Stephen Kilmartin
Planning
Ribbles Valley Borough Council

Email: ecology@lancashire.gov.uk
Your ref: CONECO/3/2013/0854
Our ref: 03/13/0584/ASM/ASP/RS
Date: 6th January 2014

Ecological comments

Planning Application No: **3/2013/0854**
Proposals: **Erection of replacement dwelling**
Location: **Sawley Lodge**
District: **Ribble Valley**

2392-12

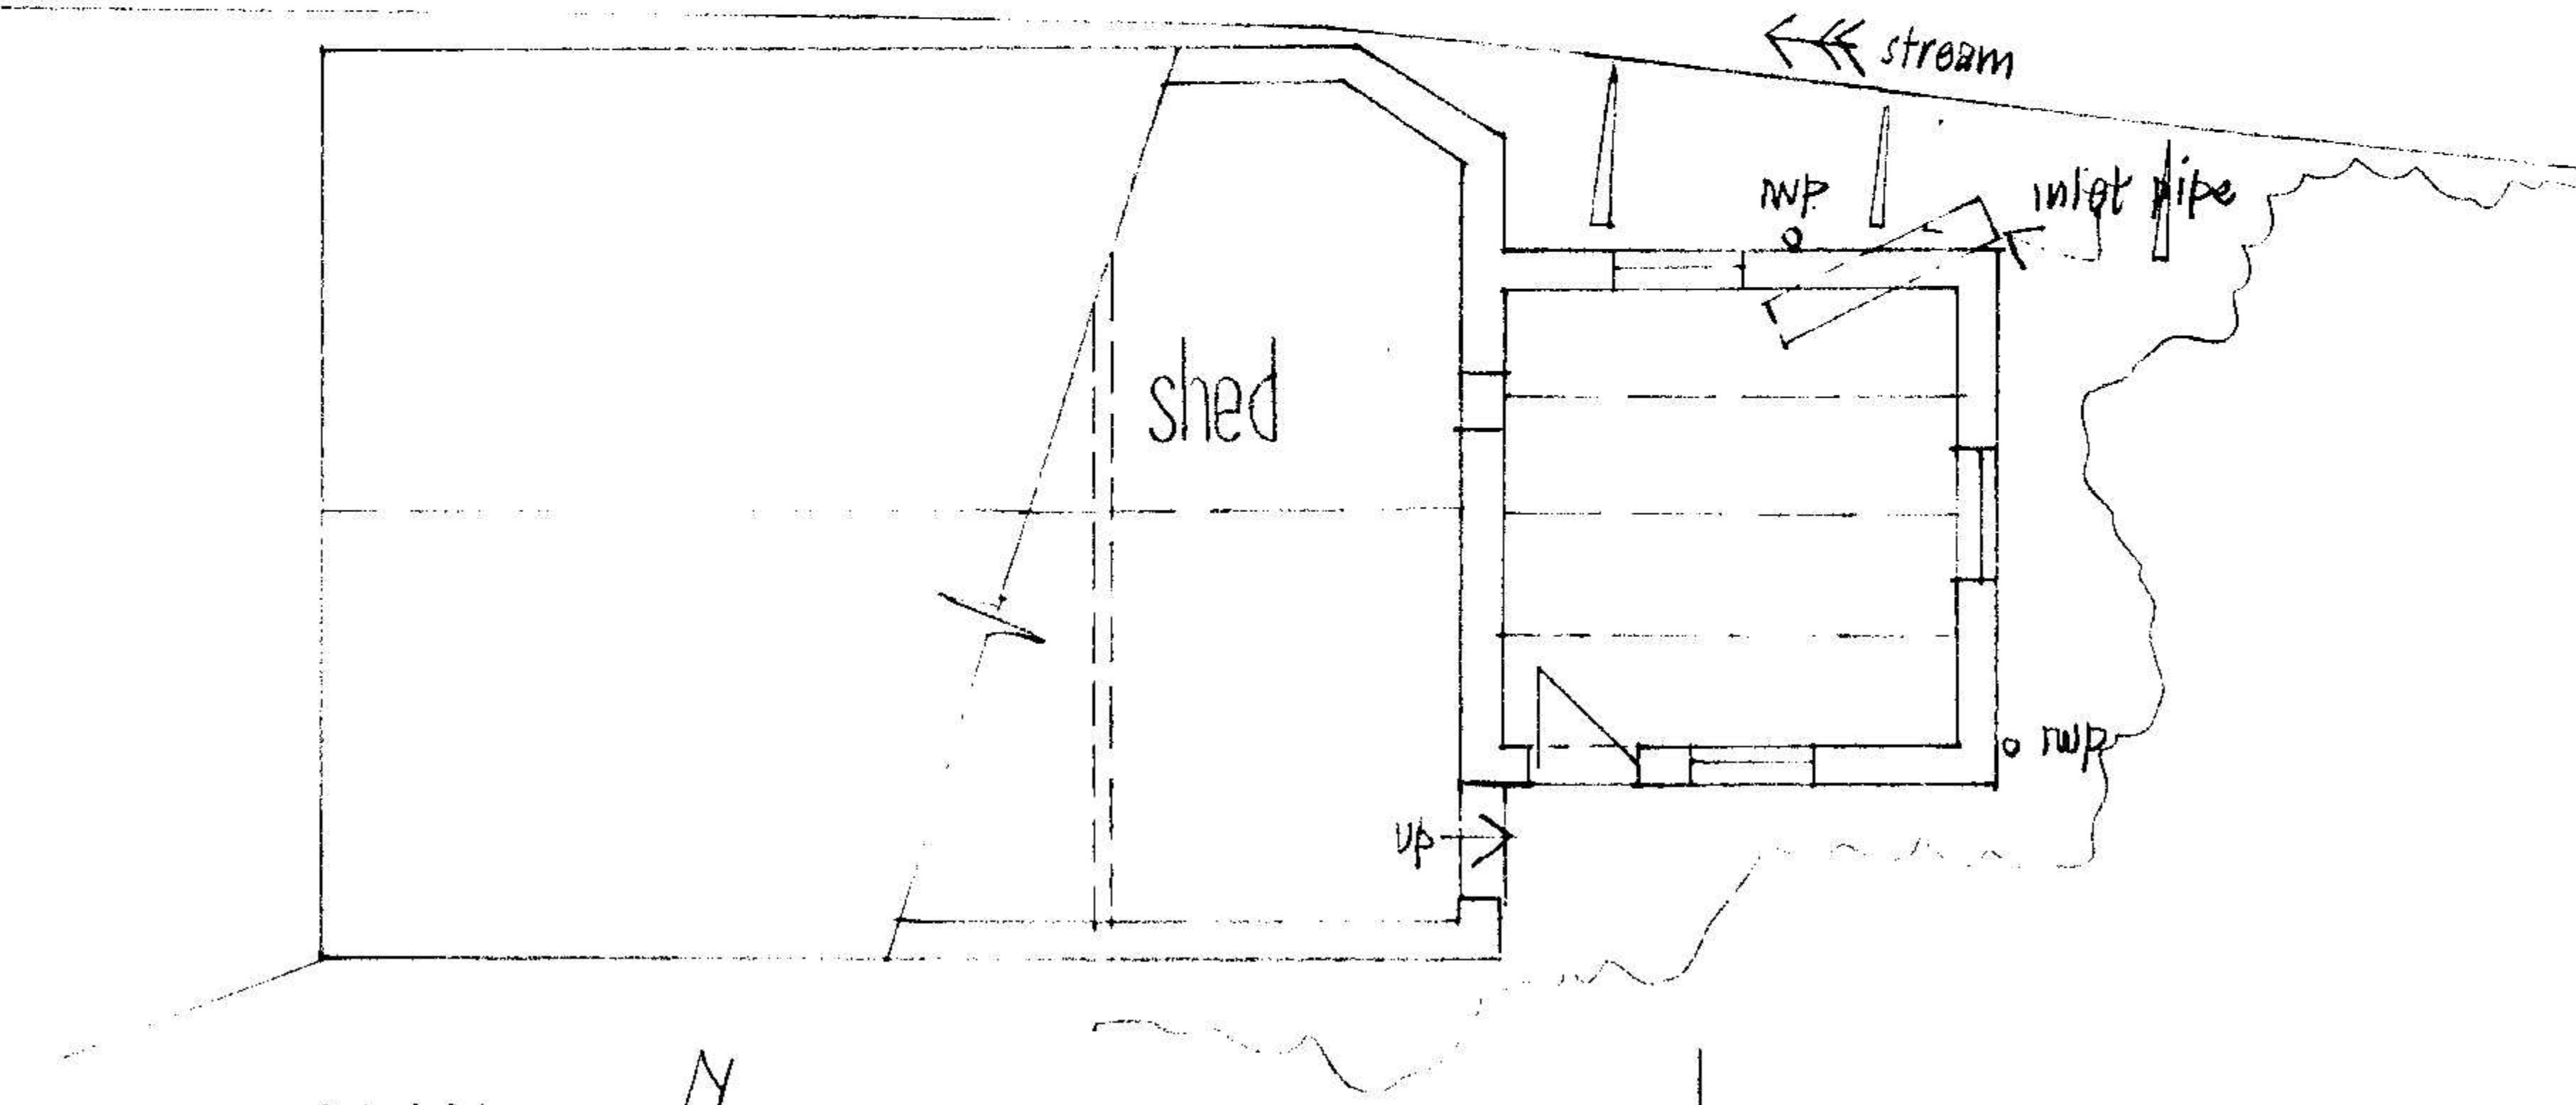
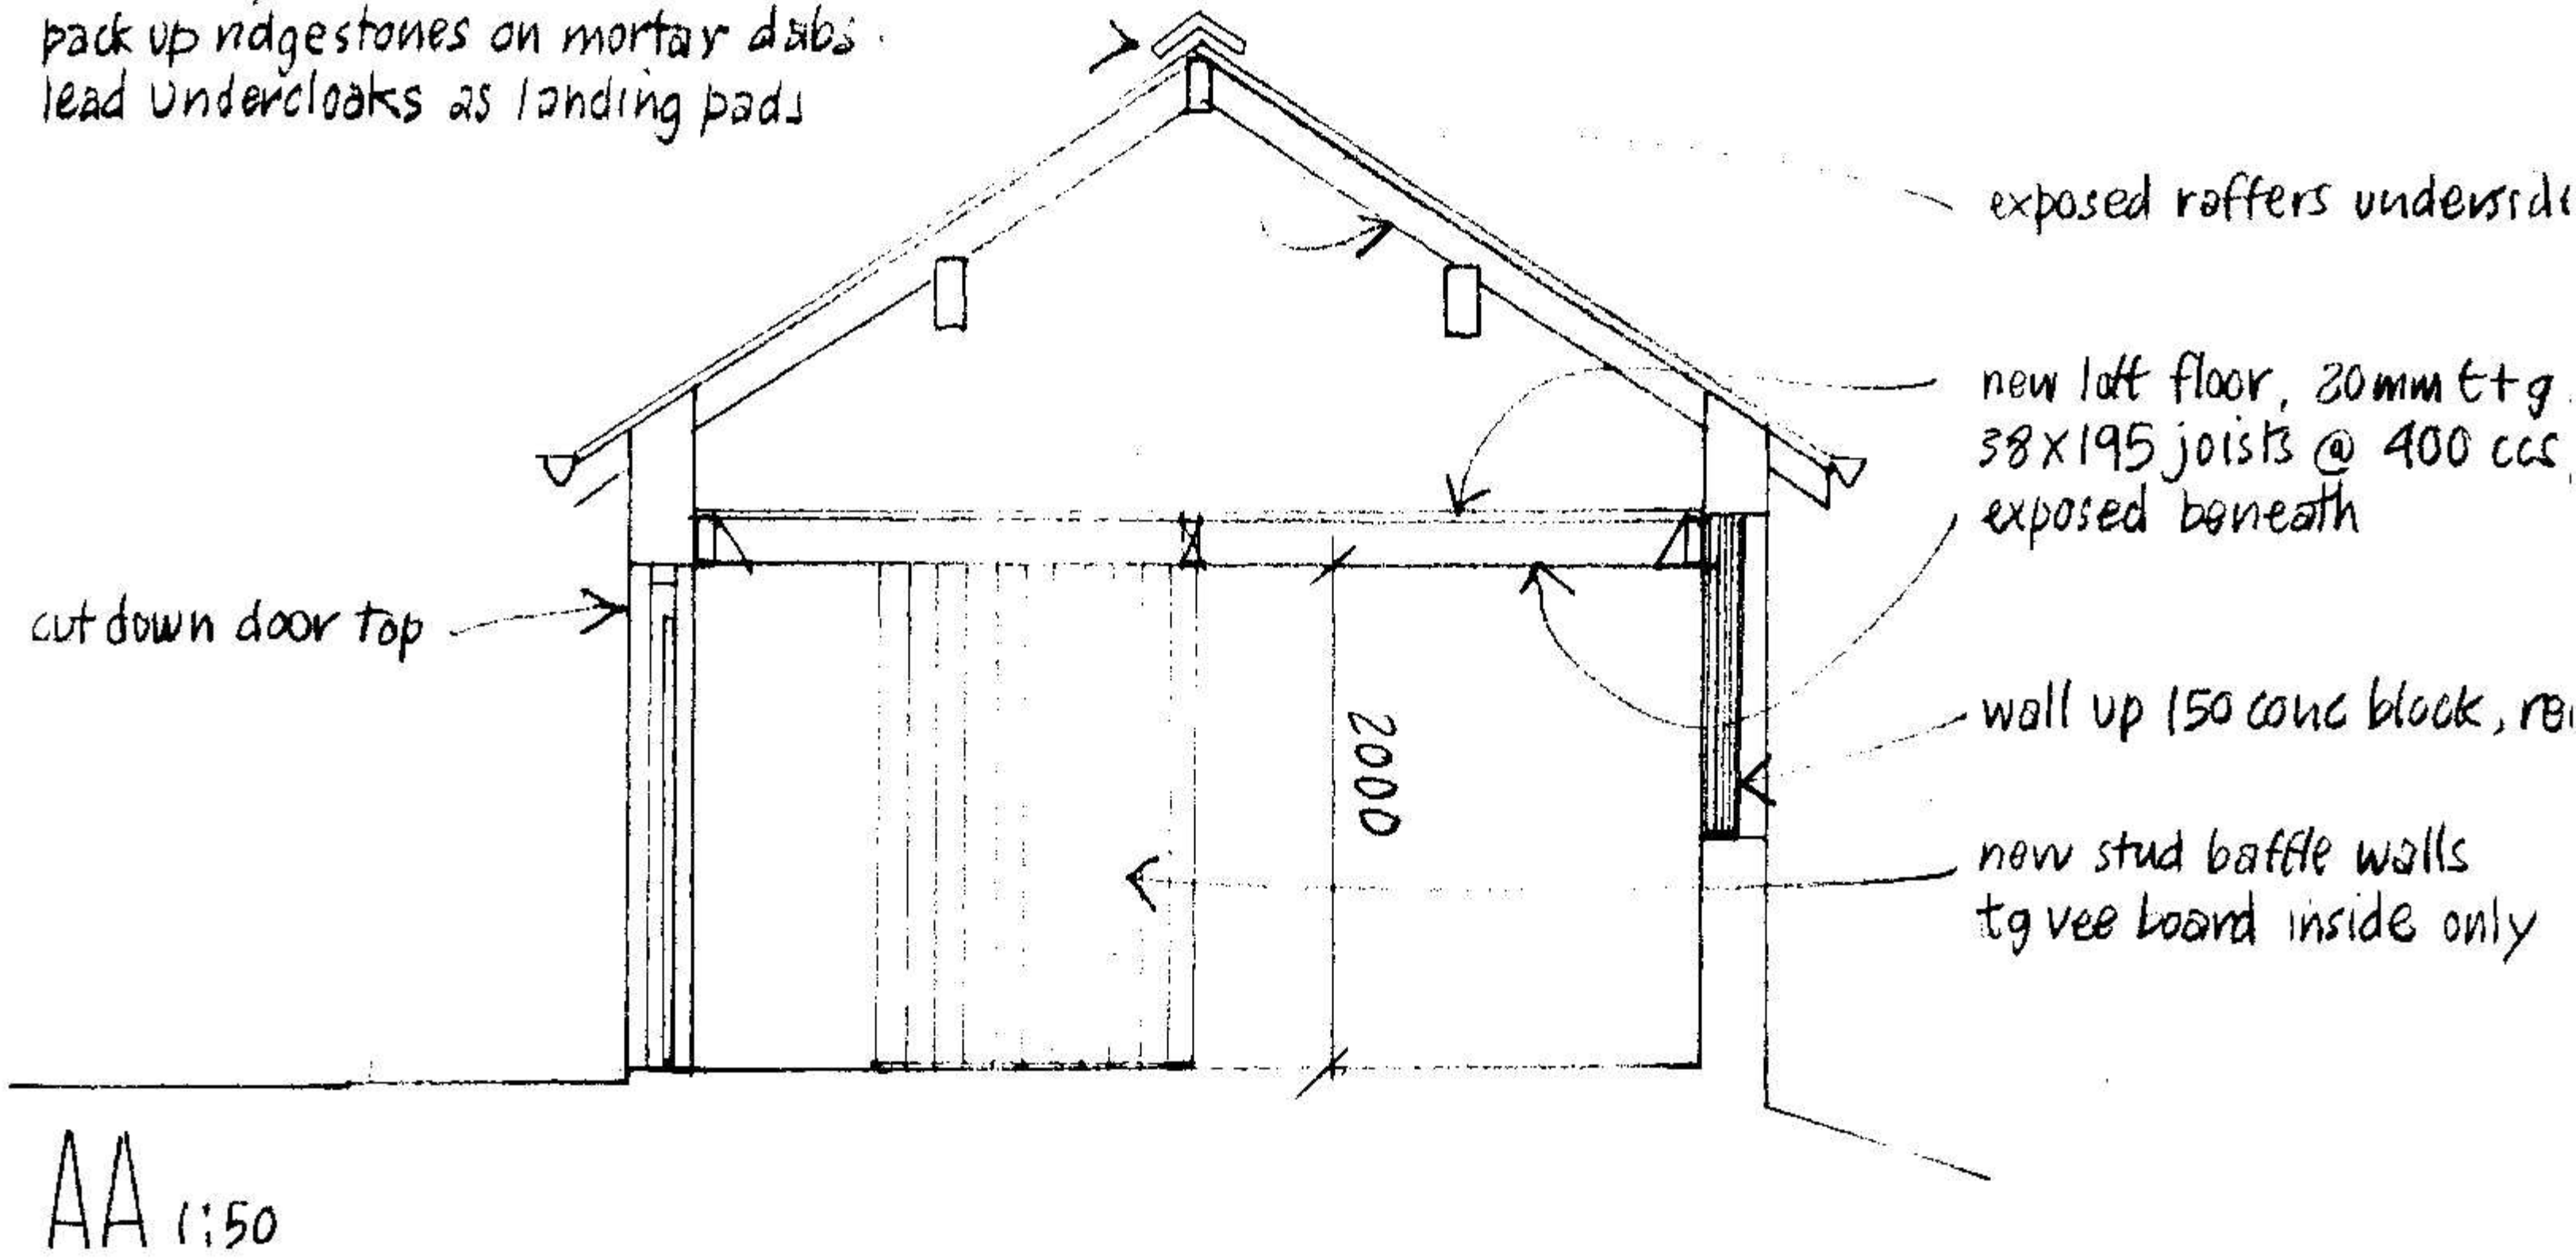
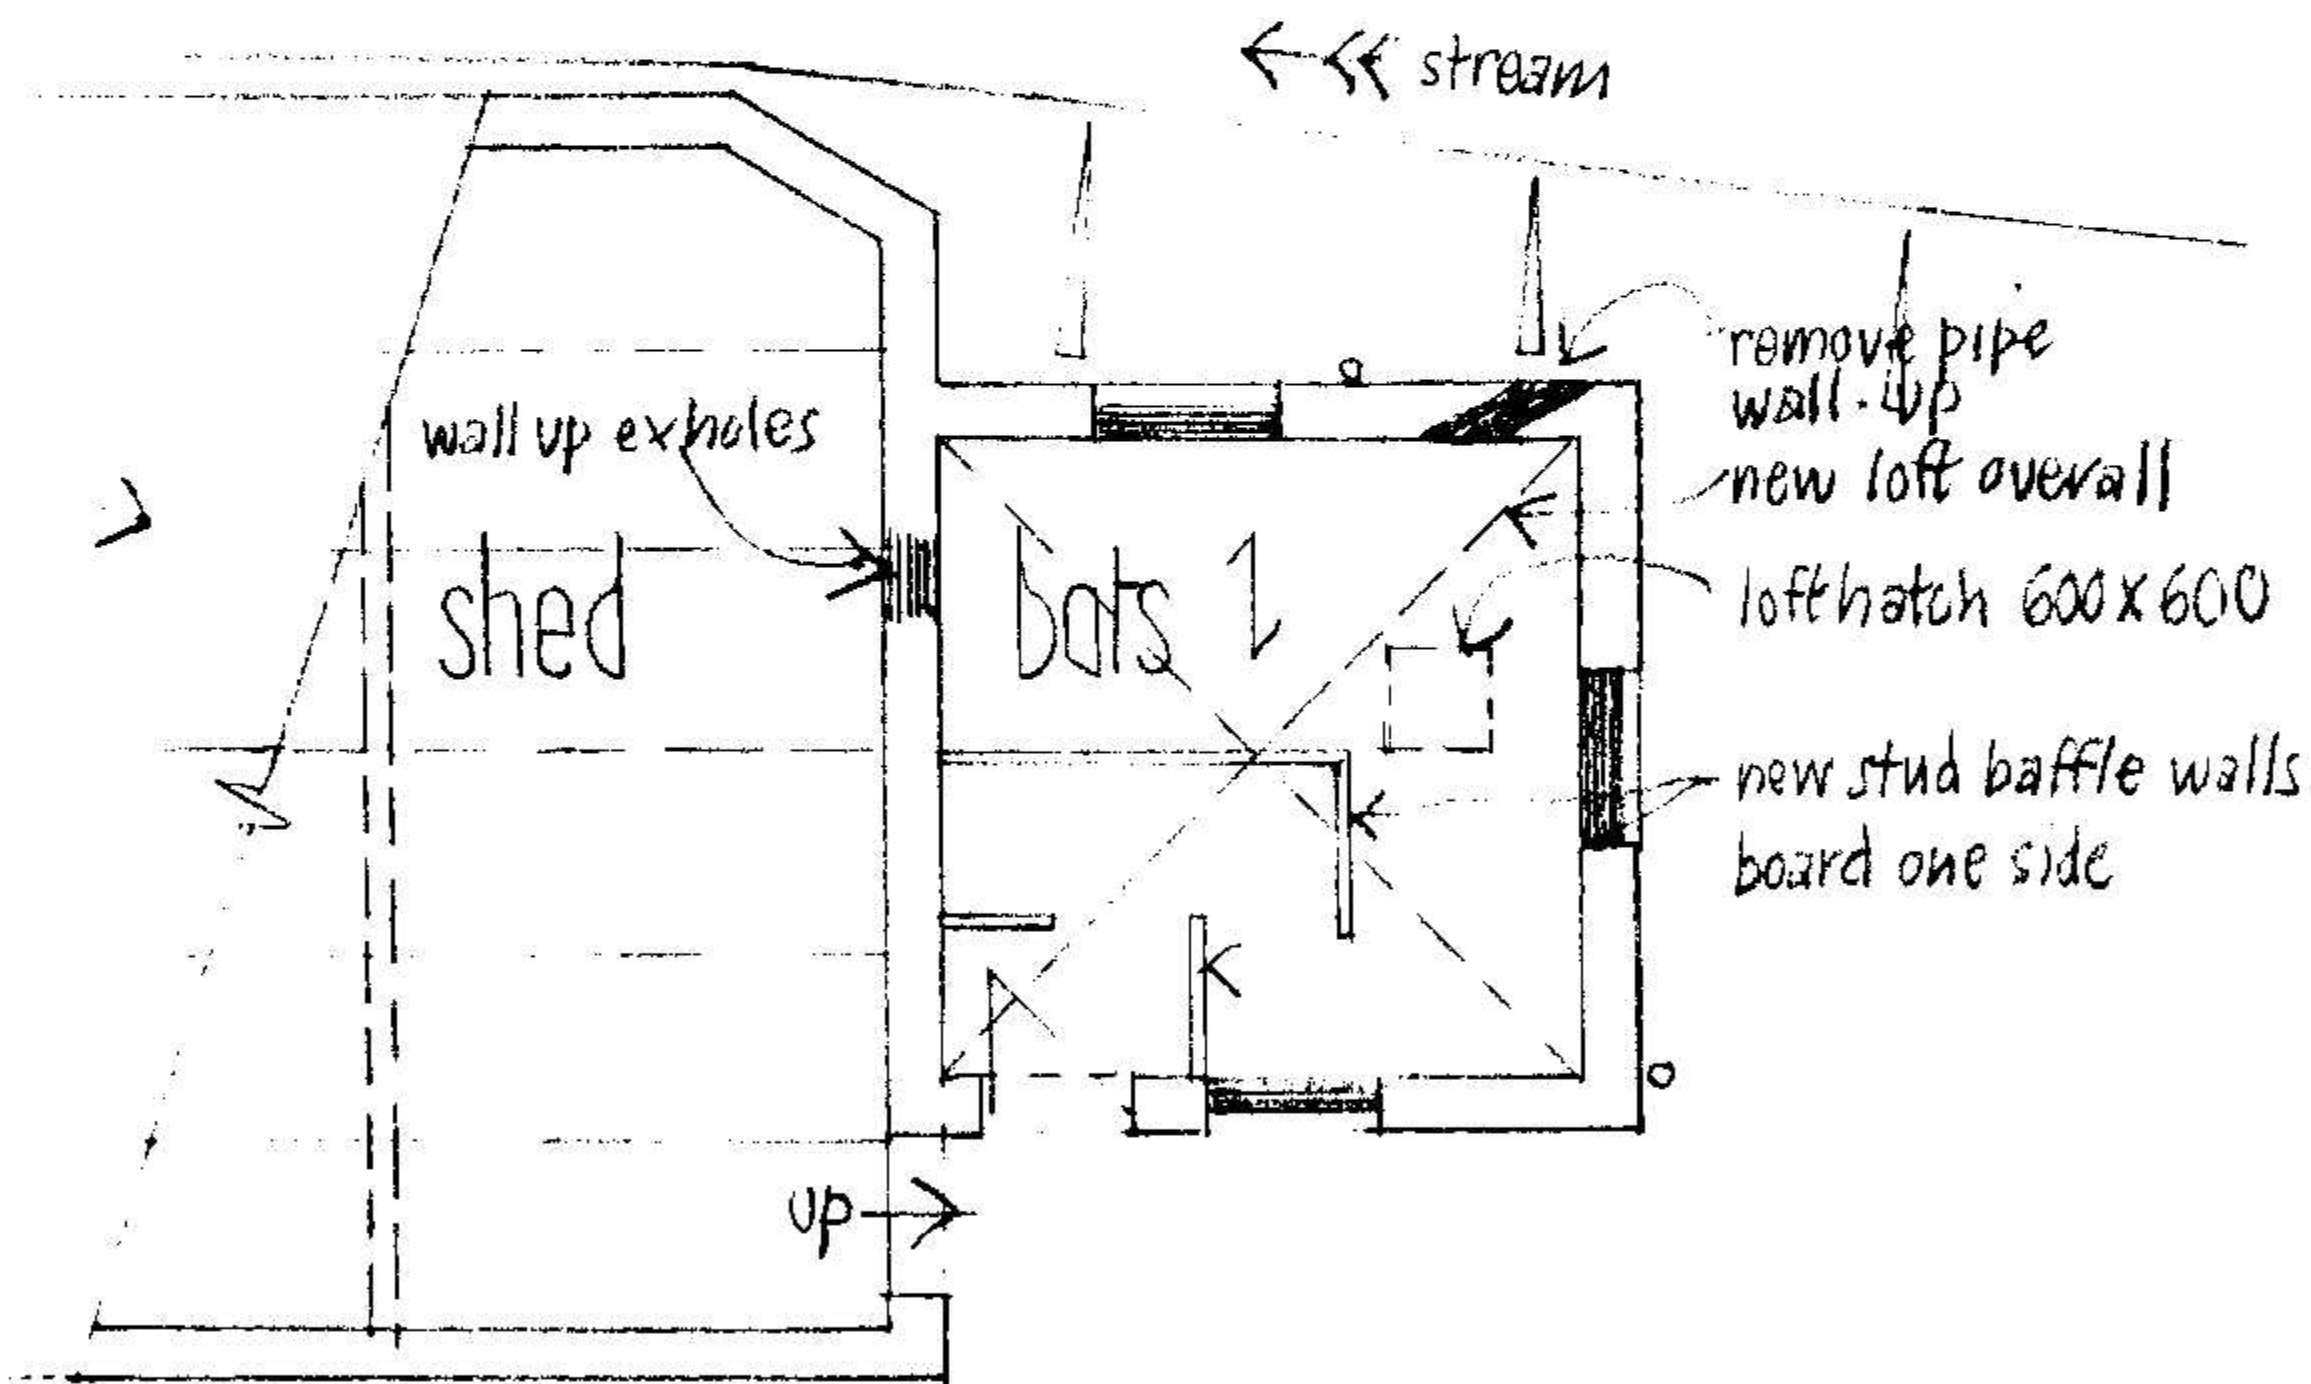
A mitigation method statement has been submitted to address the 3rd test. Although I am not able to comment on these proposals at this stage as the survey work is not yet complete, I note that the proposals involve refurbishment of an existing building and there does not appear be any information regarding the current use of the building by bats and birds. Surveys to establish the use by bats and birds (barn owls and nesting birds) of any existing building proposed to be used as mitigation would need to be submitted prior to determination of the application.

- Assessments/surveys to establish the use of the power house/hydro building to be refurbished by bats and birds (including barn owls and nesting birds)
